From: [REDACTED]
Sent: 24 July 2019 17:44
To: Laura Gibbons
Cc: Kathryn Griffiths; Caroline Green; Zoe Knott; Ryan Saul; Dorota Kaminska-Majkowska; James Lawson; Lance Else; James Hammond; Darren Mcarthur; Simon Davis
Subject: RE: Y/9818/RES and Y/97/18/DOC

Comments on the revised drainage and landscape proposals:

scheme: Land off Burndell Road Yapton
client: Bovis Homes
drawing: Hard Landscape Proposals
date: Nov. 2018
scale: 1:200@A1
drawing no: BOV22172 12A sheet 3
drawn: AE checked: DKM

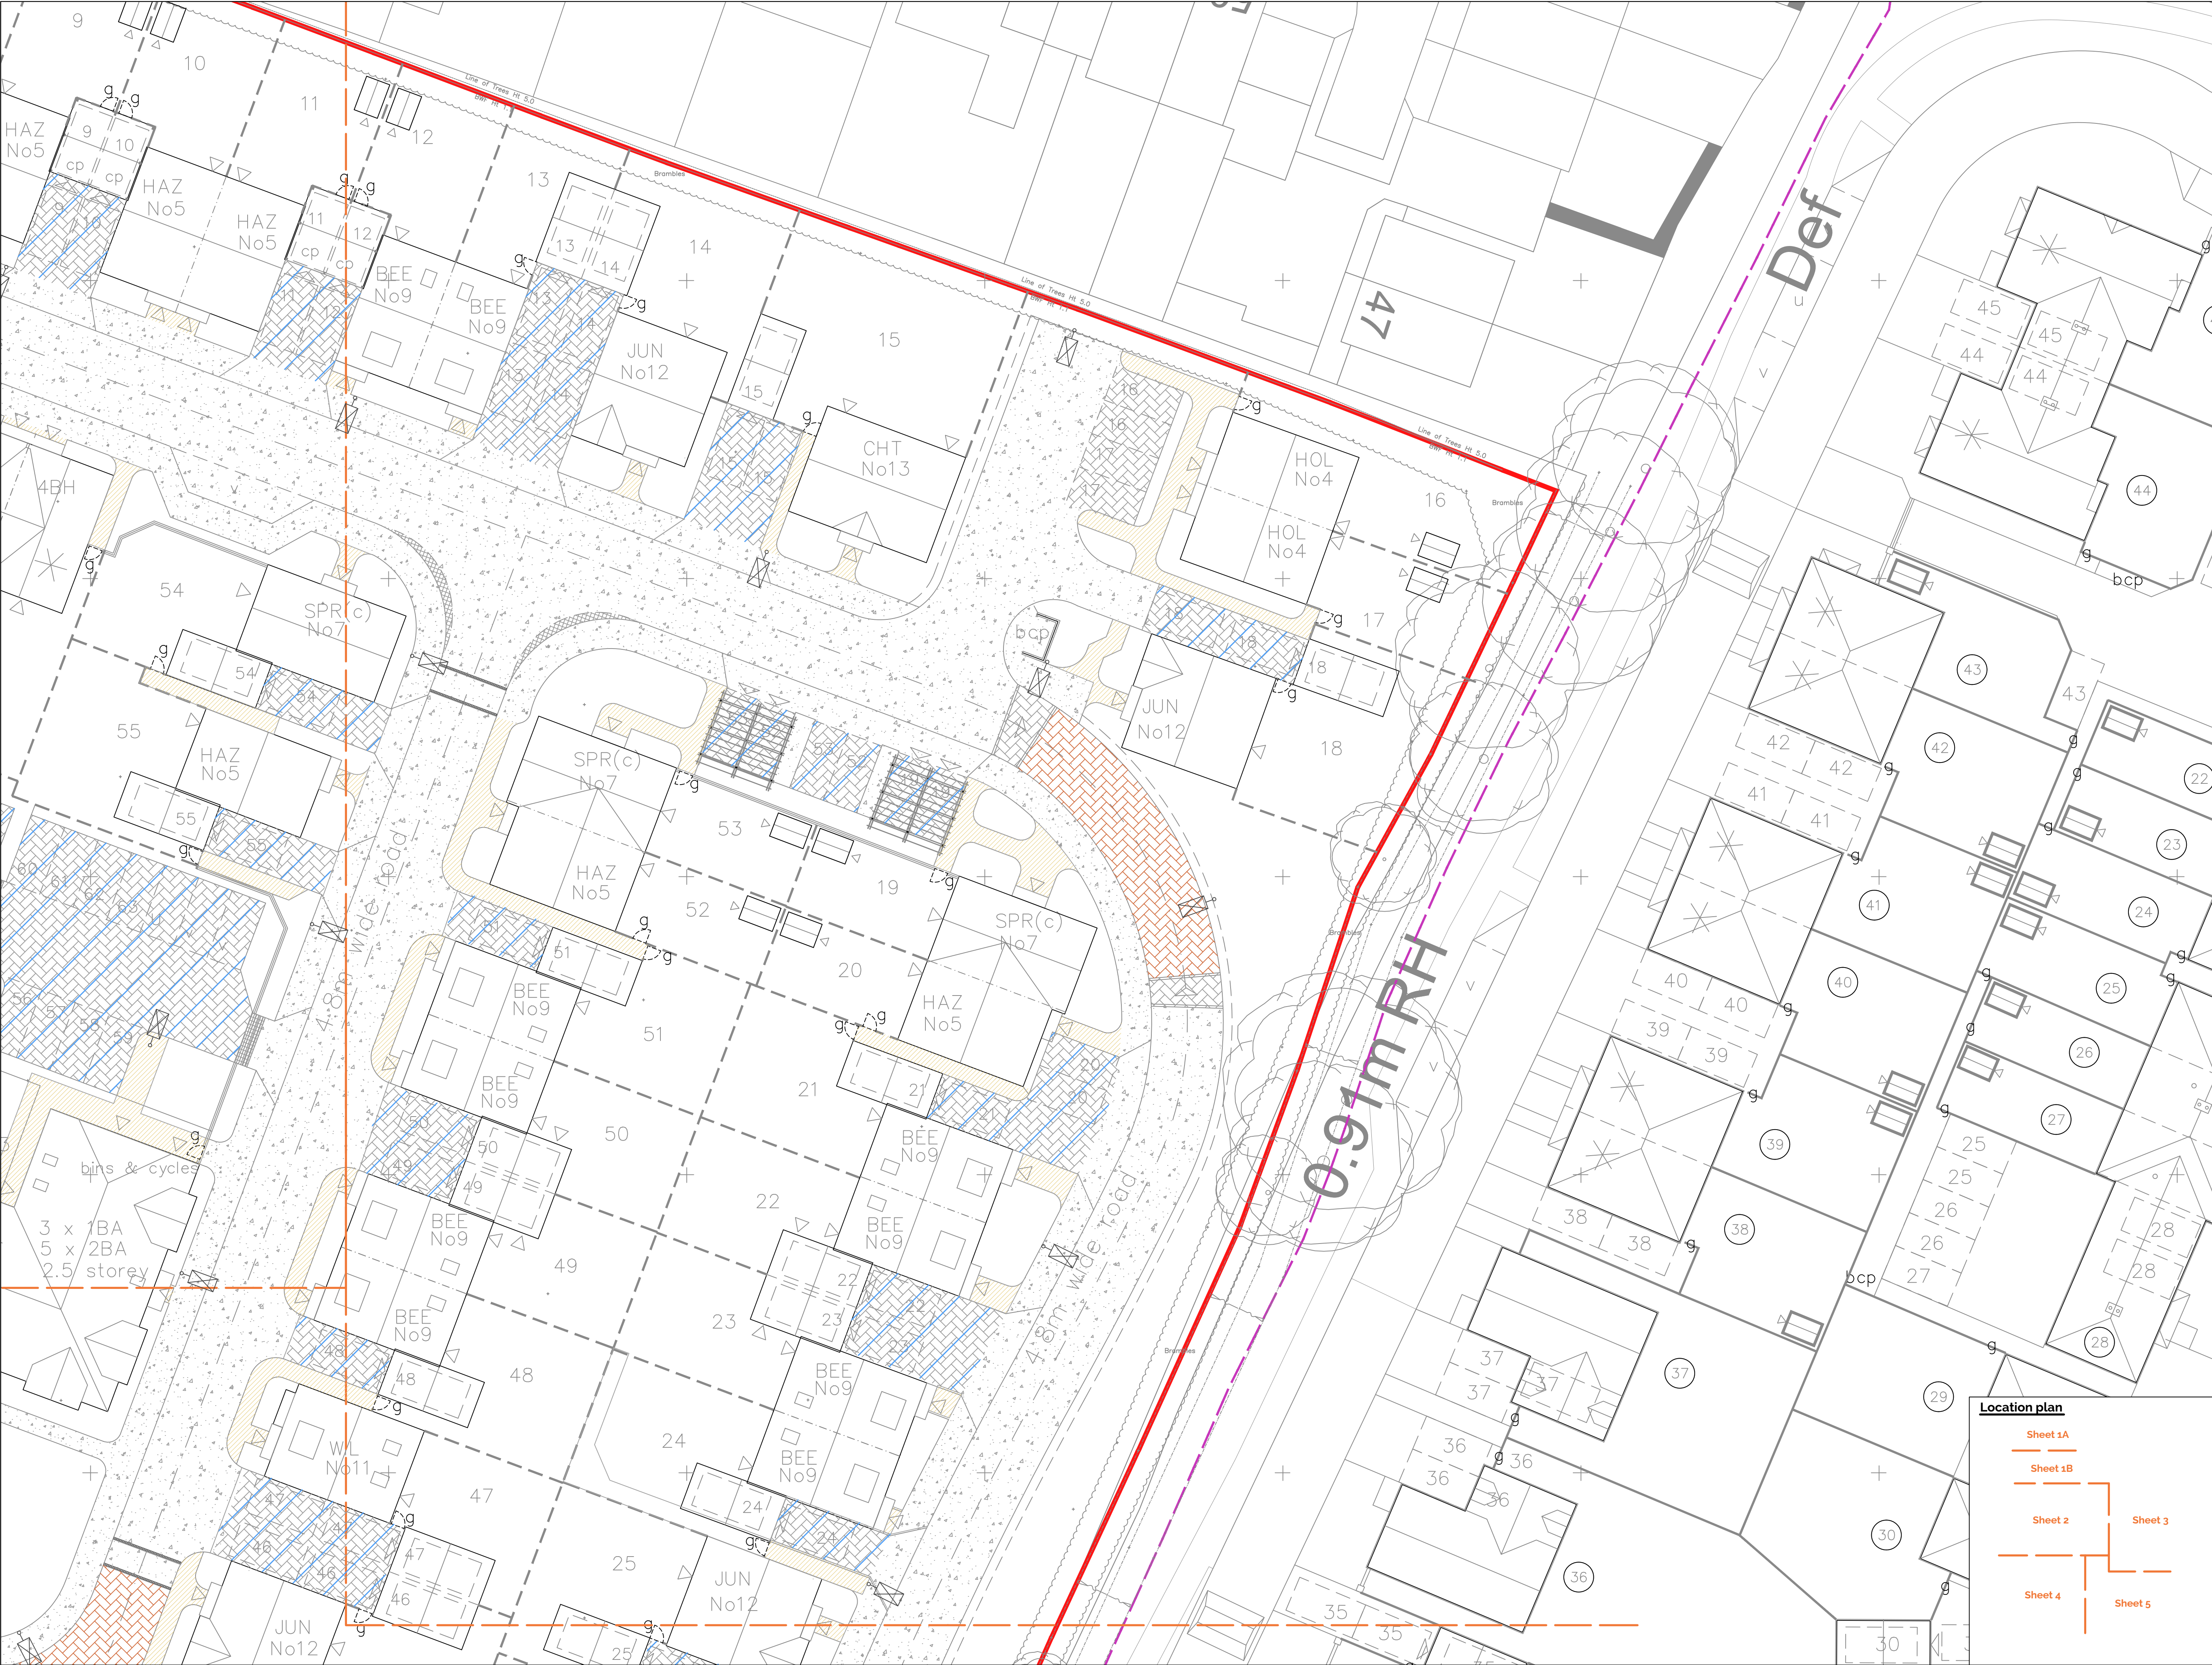
1. There are still trees proposed in close proximity to the southern-most attenuation tank. 2 no. trees close to this tank have been removed. Refer to updated ACD landscaping drawings. *On the ACD landscape drawing sheet 4 revision G there are trees in close proximity to the crate nearest the pumping station. Please can a plan be provided which shows both the proposed drainage and the proposed planting and associated potential root areas on the same drawing.*

Job Title			
LAND SOUTH OF BURNDILL ROAD, YAPTON			
Drawing Title			
PRELIMINARY ENGINEERING LAYOUT			
Client			
BOVIS HOMES			
Scale	Date	Designed	SG
1:500 @A1	NOV 18		
Drawn	Checked	Approved	RS
SOM	LH		
Job No	Drawing No		Rev
18-070	18-070/103		P

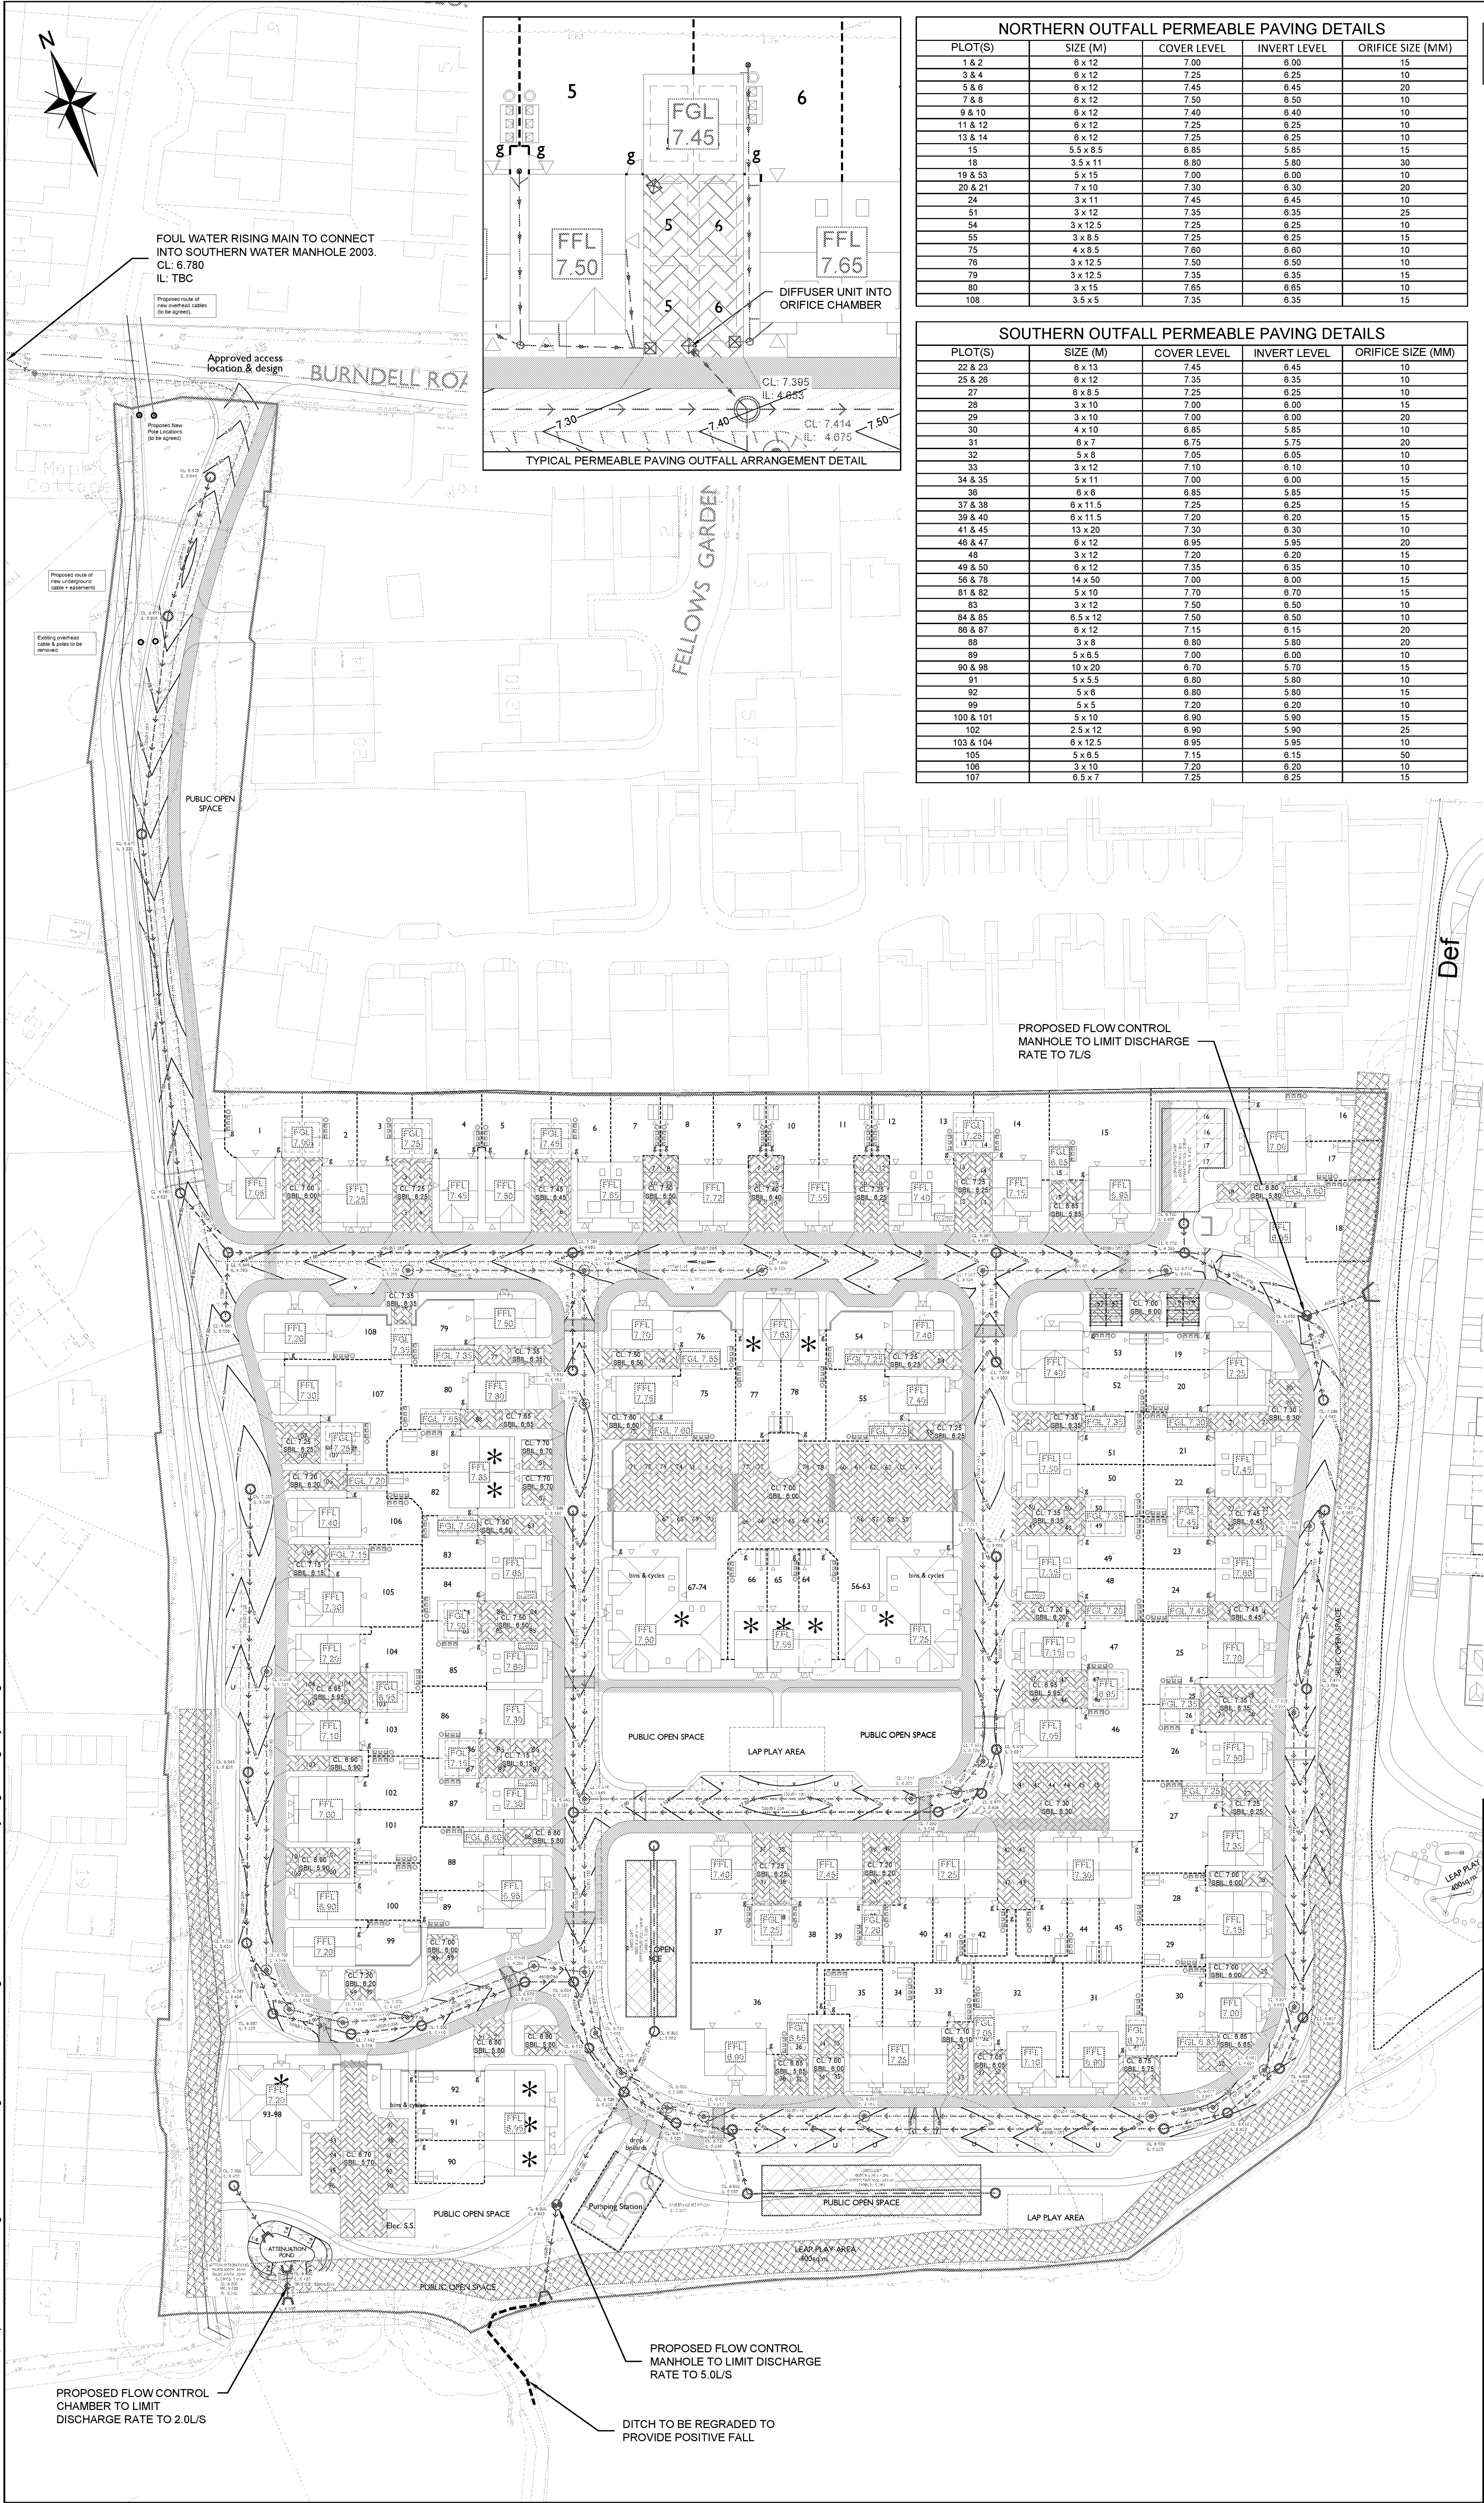
5. Calculations for attenuation basin attached. *Can you provide the full catchment calculations for this?*
6. We are proposing to diffuse rain water from roofs into the permeable paving and then connect the permeable paving to the wider sewer network (via a control). We show this typical arrangement, which applies to every drive, on the top right (inset) of drawing 18-070/103. *What size orifice are you proposing?*

6. Standard detail updated to show diffuser and control chamber together. Plan updated to show incoming surface water diffusers for typical drive. Permeable paving depths added to drawing (notes). Refer updated plans provided. *To clarify, are you proposing on diffusing rain water from roofs into permeable paving and then connecting the permeable paving to the wider network? You don't actually show control chambers near permeable paving on the layout. Please provide details on layout plans of the connectivity proposed.*
